September 4, 2024

**RE: Event Center
1611 Airtech CT. SE
Erosion and Sediment Control Plan
File: N15D017**

This letter is a response to the comments dated August 20, 2024, and is being provided with resubmitted SWPP documents. Please refer to the response under each comment.

Landscape Plan

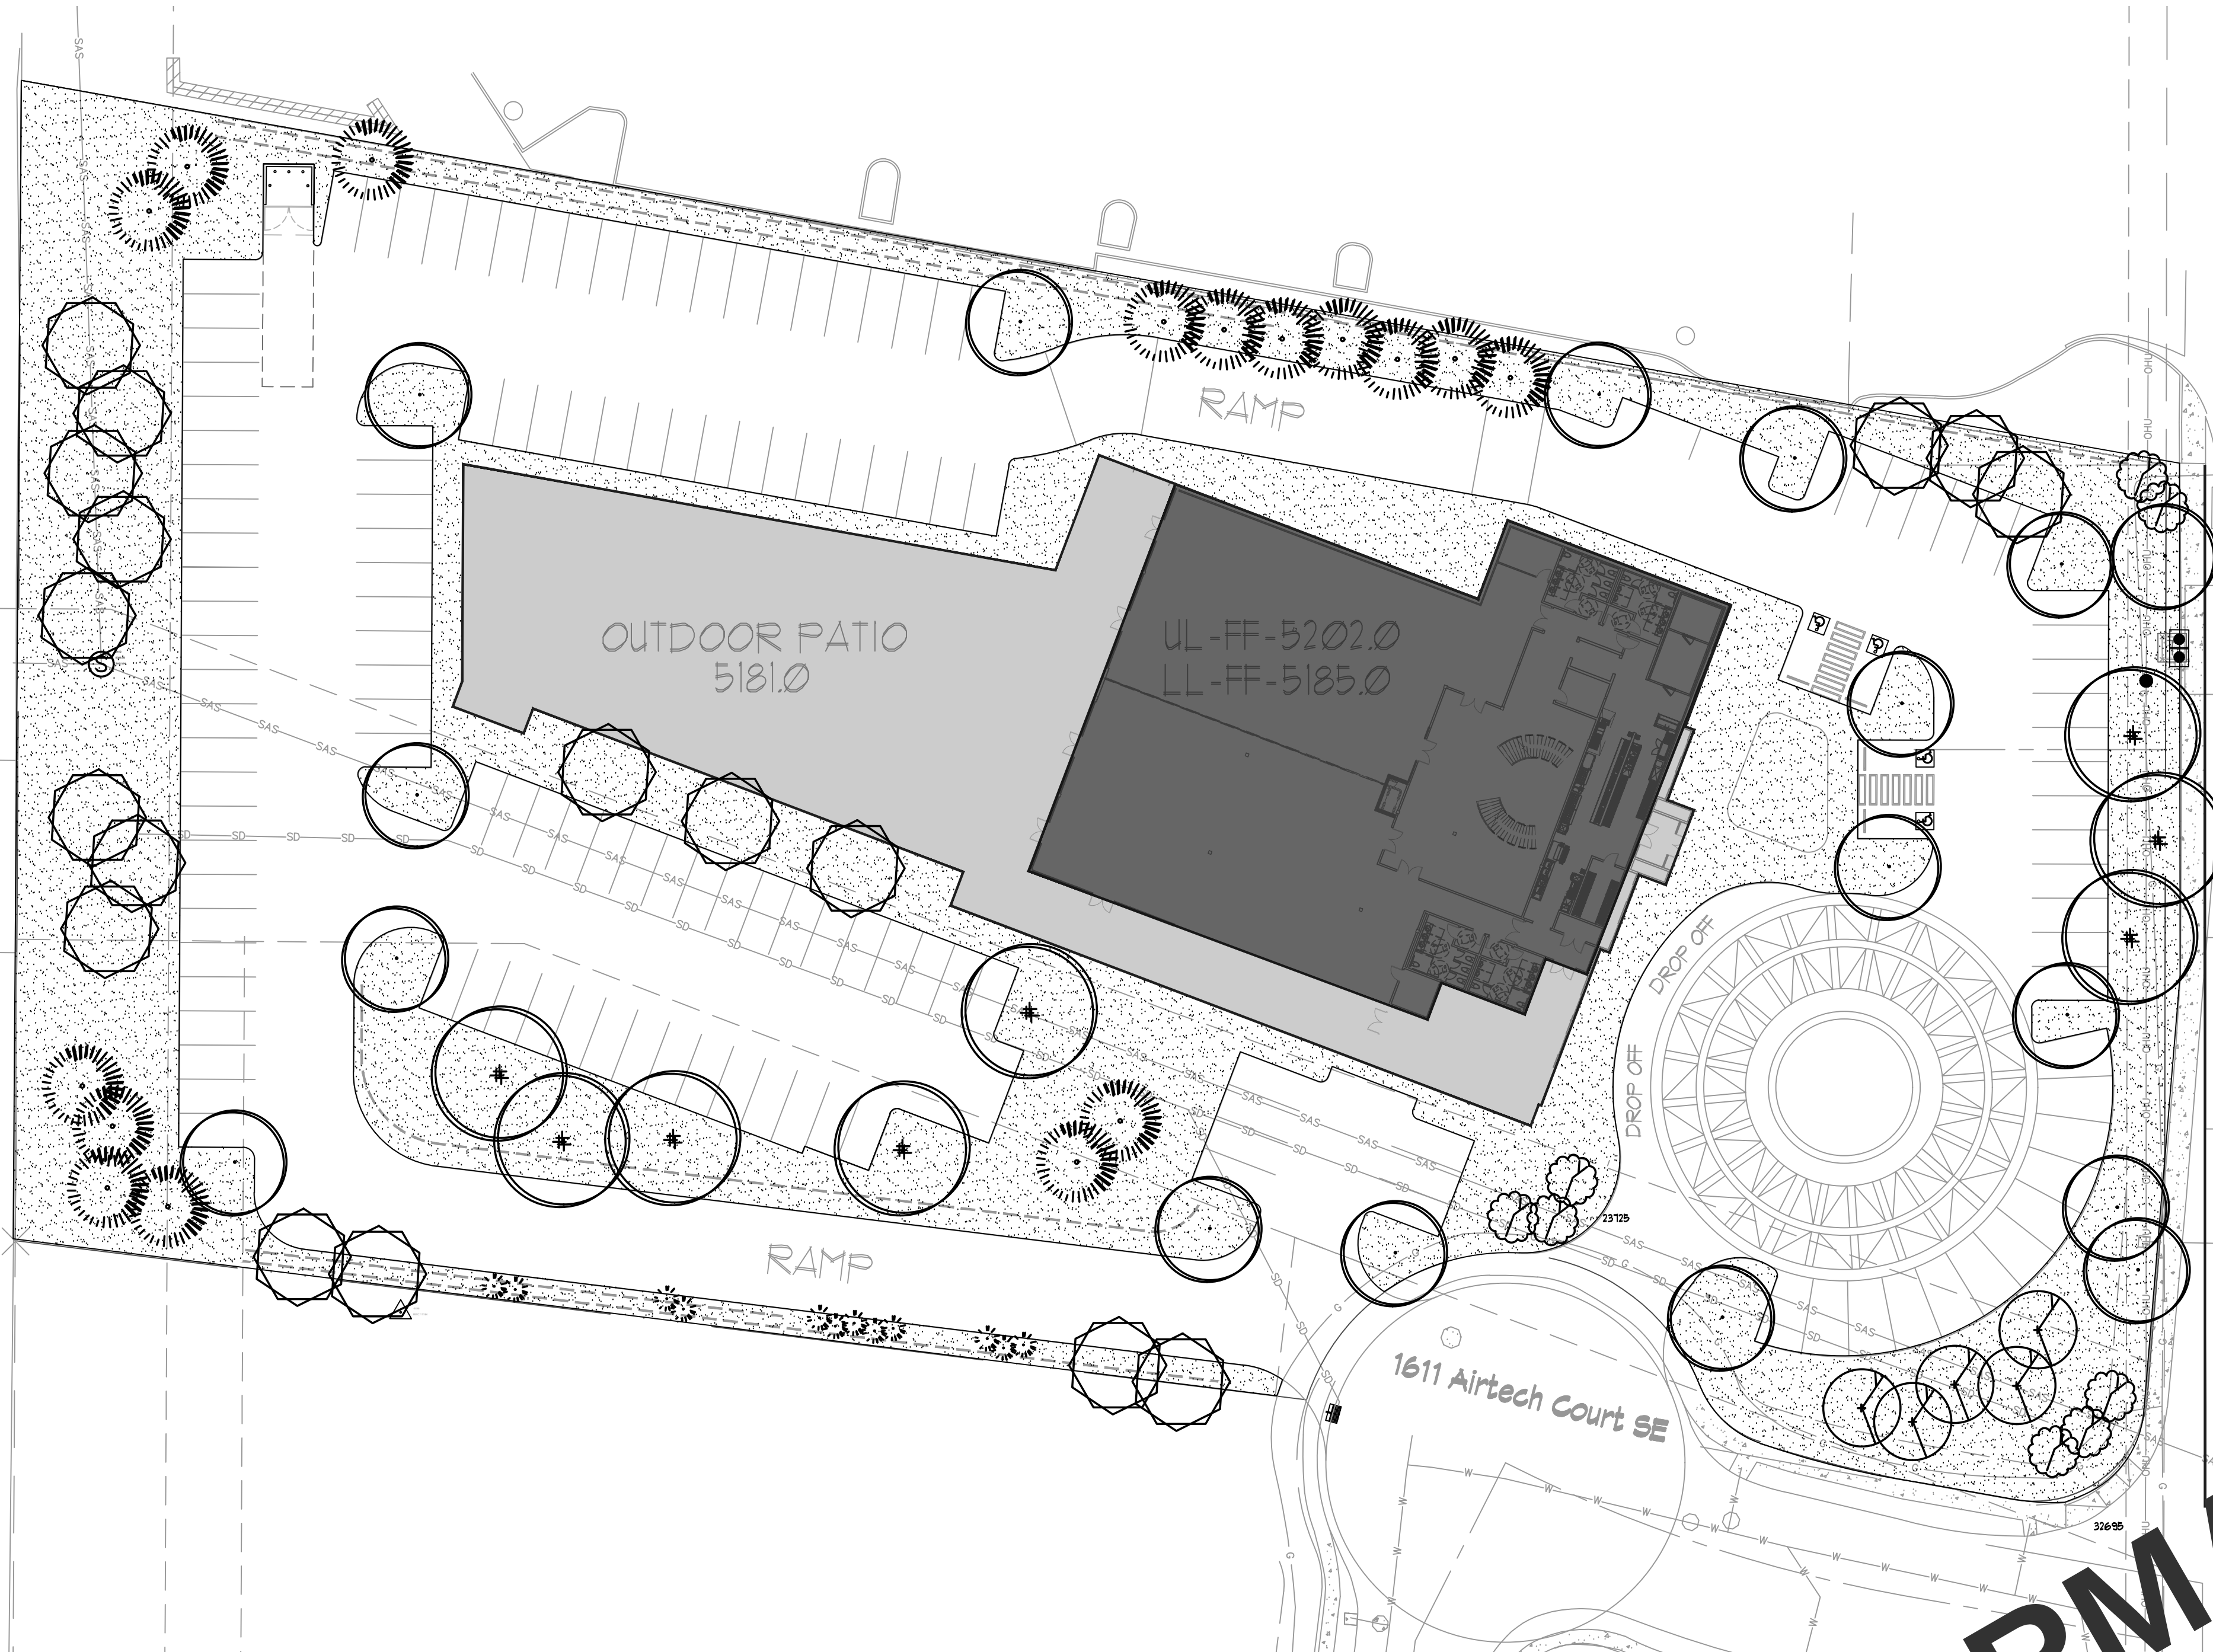
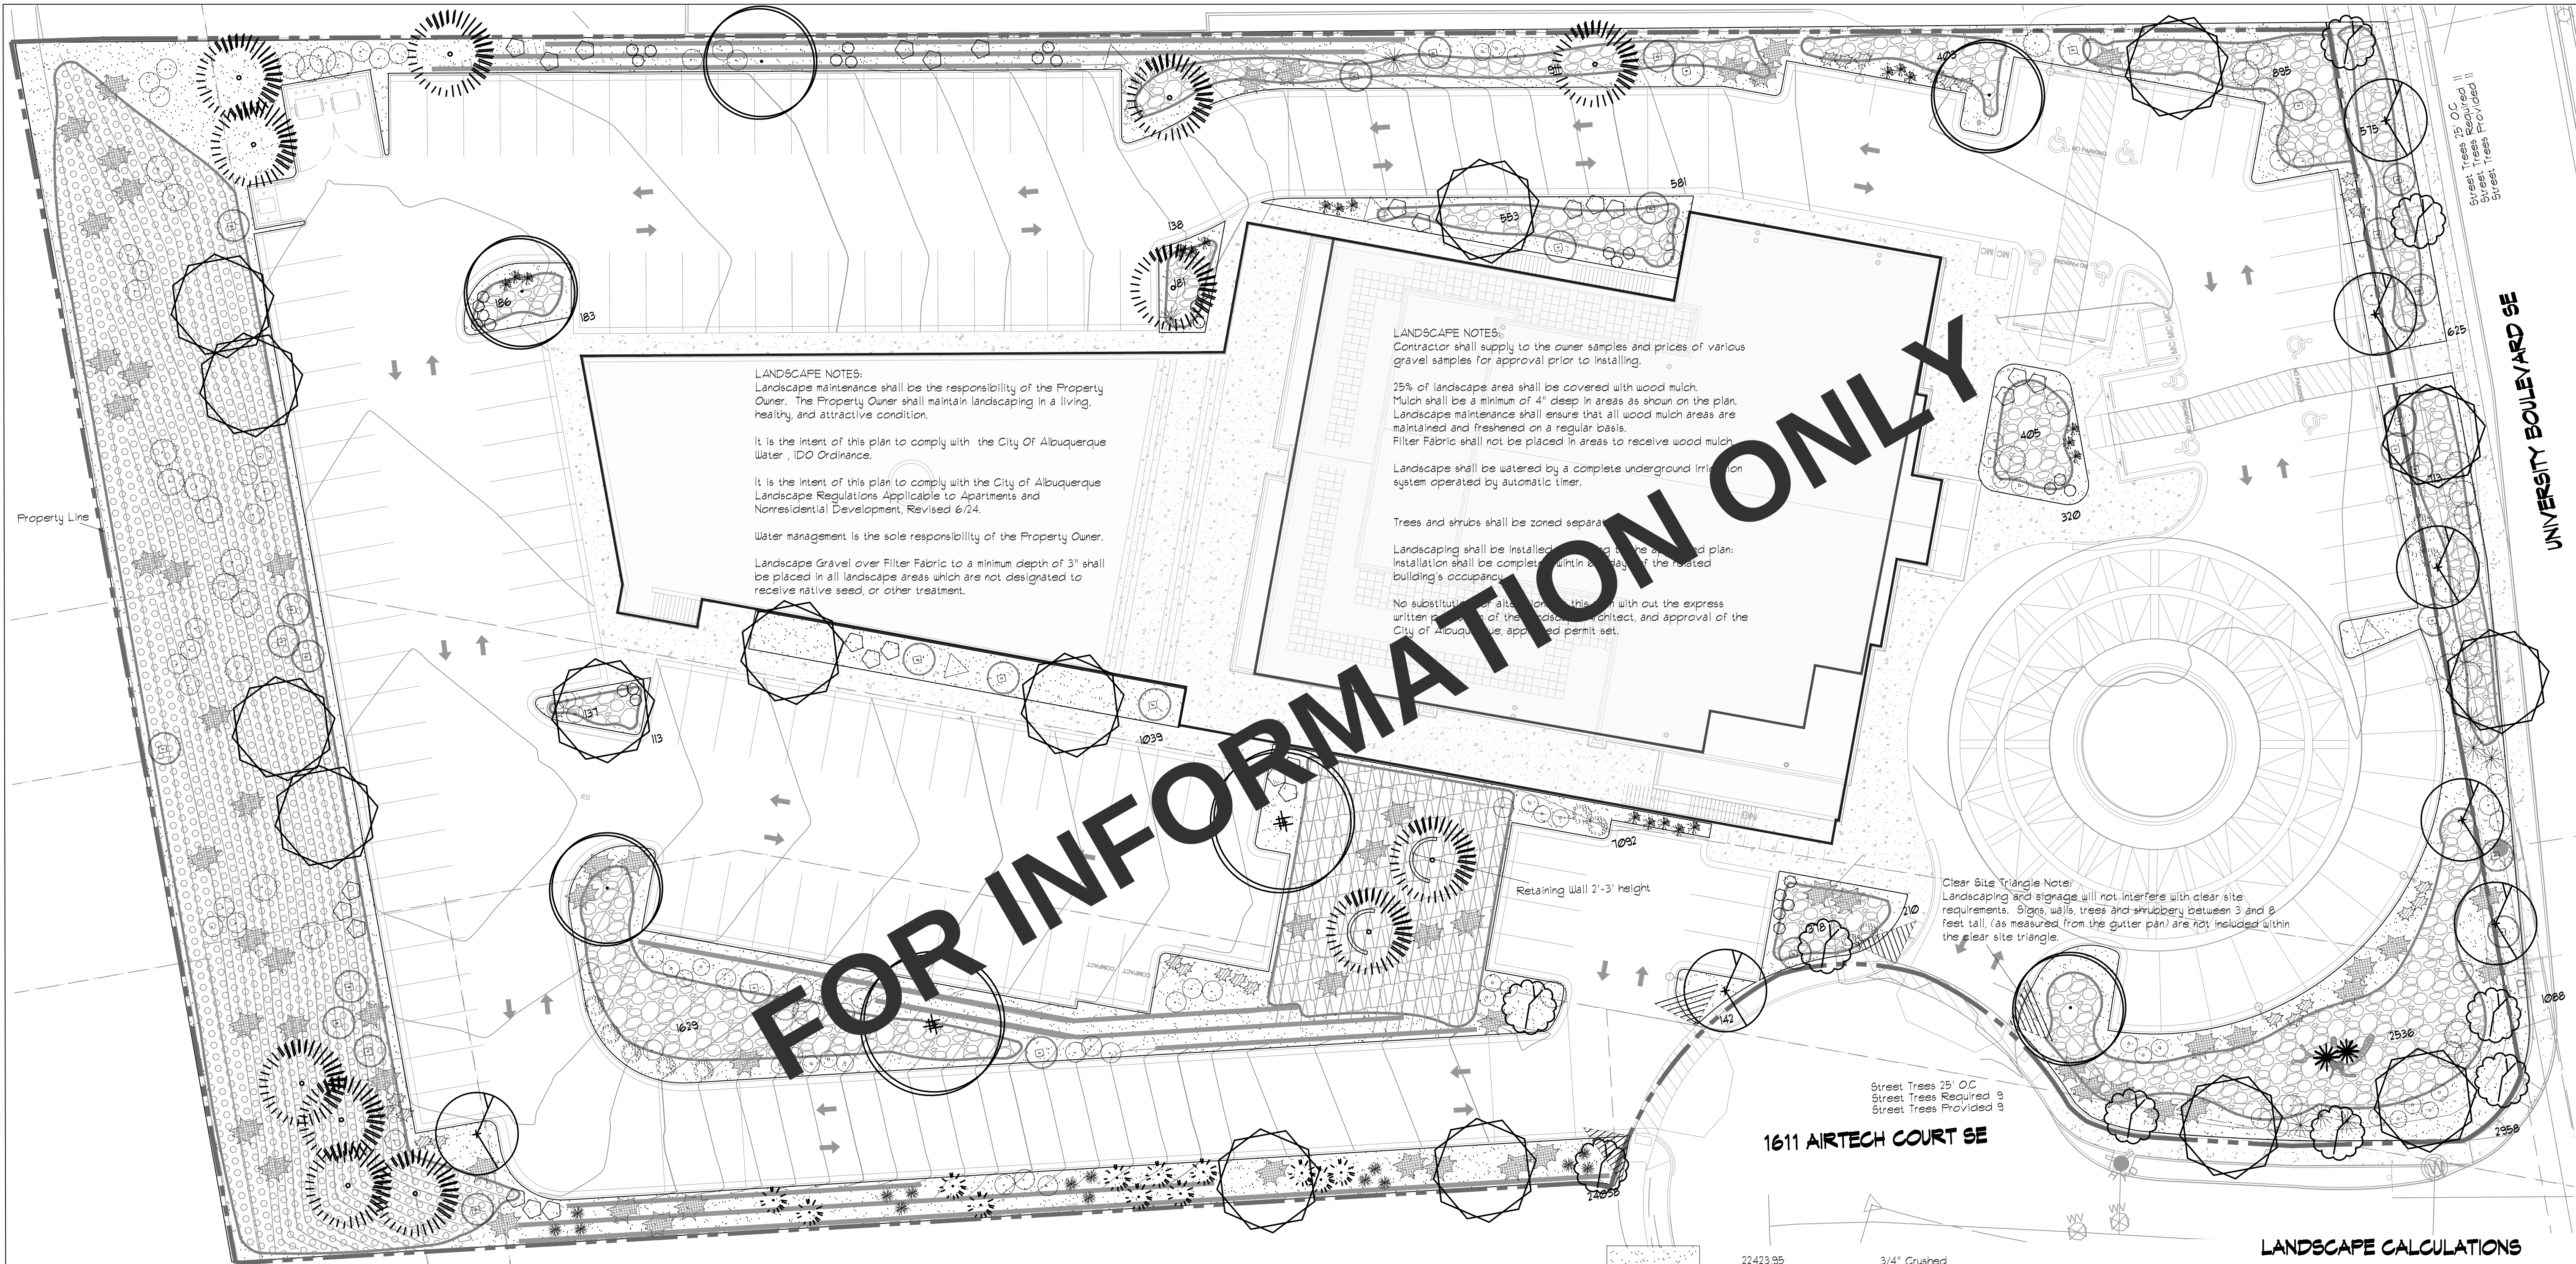
The ESC Plan is fuzzy and hard to read. The engineer's stamp is illegible and missing from some sheets. The Landscape sheets should be submitted separately for information only and should not be included in the ESC Plan set. The sheets are 8.5" x 11", but the required size is 22" x 34". All sheets in the ESC Plan sets must be on a standard-size sheet with a standard border and title block as required by the drafting standards in the city's Development Process Manual (DPM) Part 4-2, and templates are at

- **Response:** EPC plan is now on standard sheet size 22"x34". Wording "For Information Only" were added to the Landscaping Plan.
